RE: OBJECTION FOR ERECTION OF DETACHED DORMER BUNGALOW ON LAND ADJ. 6 REINWOOD AVENUE, QUARMBY, HUDDERSFIELD, HD3 4DP

LPA REF: 2024/91091

DRAWING TITLE
**EXISTING AND PROPOSED SITE
 PLANS**

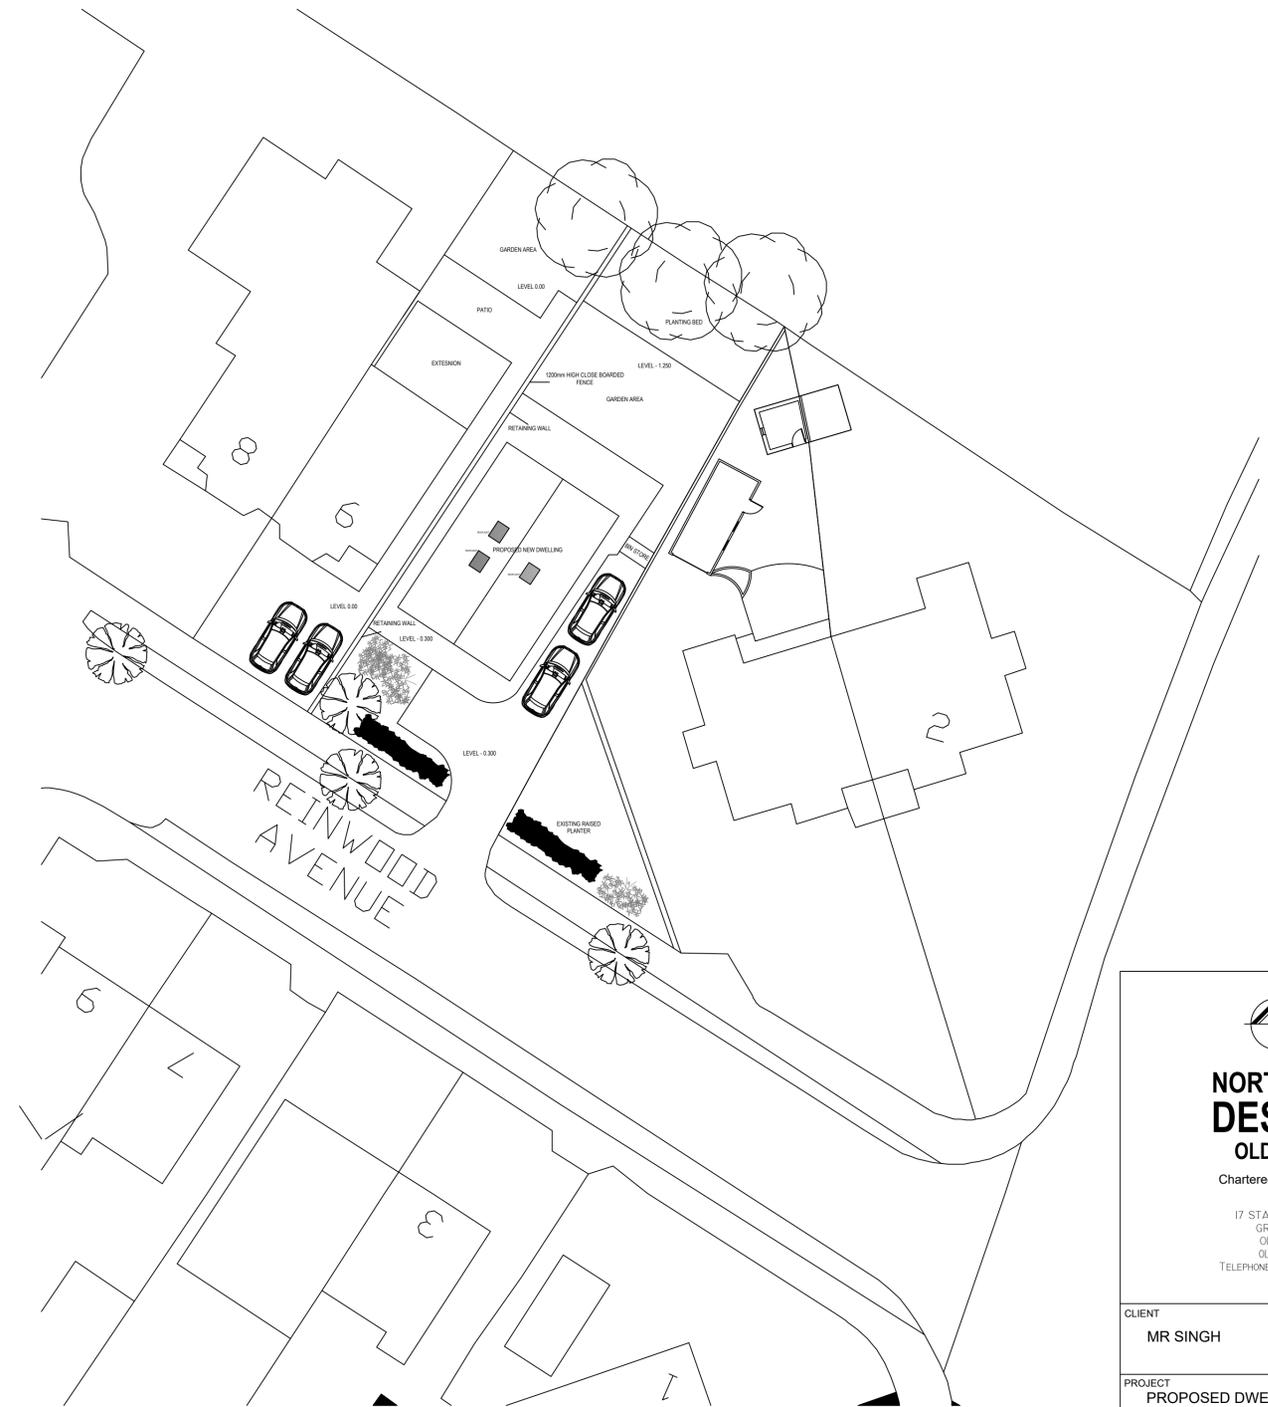
The footprint approved in the previous application measured 7.8m (w) x 10.4m (l). In contrast the proposed footprint now measures 7.6m (w) x 11.1m (l). Whilst the width of the proposed dwelling has been reduced by 0.2m, the length has been increased by 0.7m. The proposed increase in the length of the dwelling would cause additional overshadowing of our clients' property and private amenity space and would result in the dwelling appearing more prominent and intrusive from our clients' property due to its increased form and massing.
